Subject: RE: Few other points RE: FW: Taco Bell at 1363 Washington Avenue, Portland, ME

Based on an email I received yesterday from Angel please note the below responses pertaining to your previous comments.

TACO BELL  
 1363 WASHINGTON  
 PORTLAND, ME  
 PREPARED BY: JOHN BUJAKE  
 ACCUSERV LIGHTING & EQUIPMENT  
 877-707-7378  
 502-961-0357 FAX  
 jbujaake@accu-serv.com  
 FEBRUARY 22, 2016

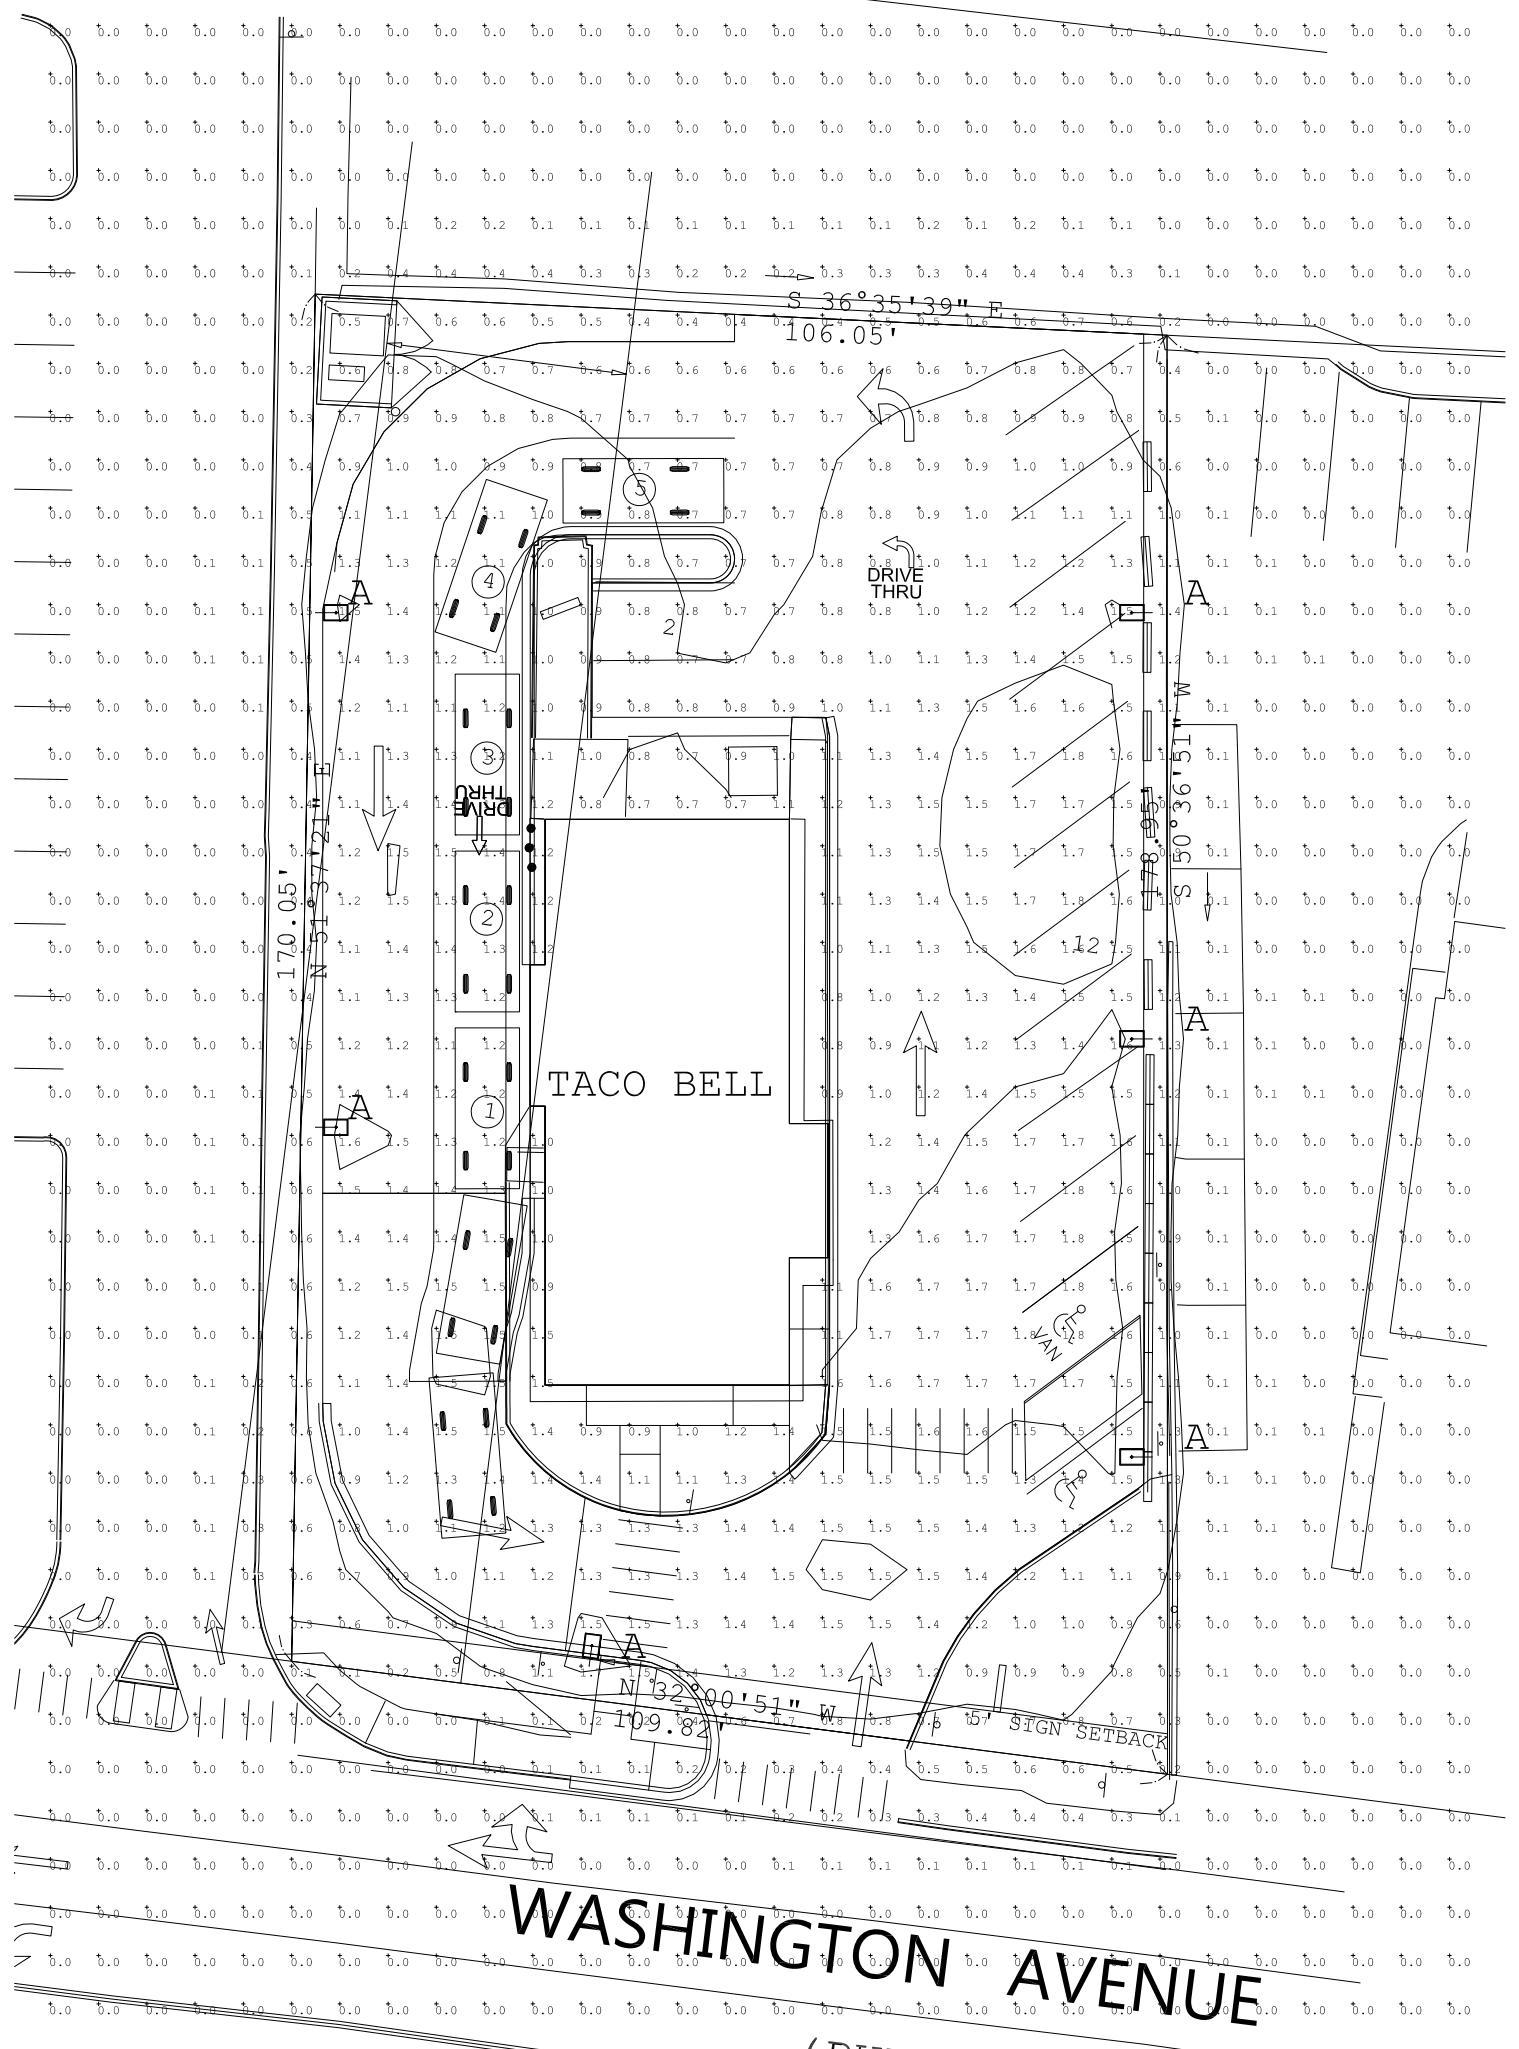
2. The material of the slat wall is aluminum per the attached detail and we have updated the rendering to state the material accordingly.
3. See attached updated site lighting plan/photometric which includes building light sconces noted (fixture TB on the attached photometric plan). Pertaining to the parking lot lights (fixture A on the attached photometric plan), the site lighting vendor has changed the fixtures from 396W fixtures to 52W fixtures and reduced the pole height from 25' to 17'-6" along with changing the location of some poles. This brings the light levels below the 5 fc maximum allowed. Average noted on the photometric plan is 1.25 (1.25 average intended per code). The max illumination at a property line per code is stated at 0.1 FC except where abutting industrial or other non-sensitive area. As the adjacent sites are similar in nature (no parks, residents, etc) the photometric plan should meet the intent of the code.
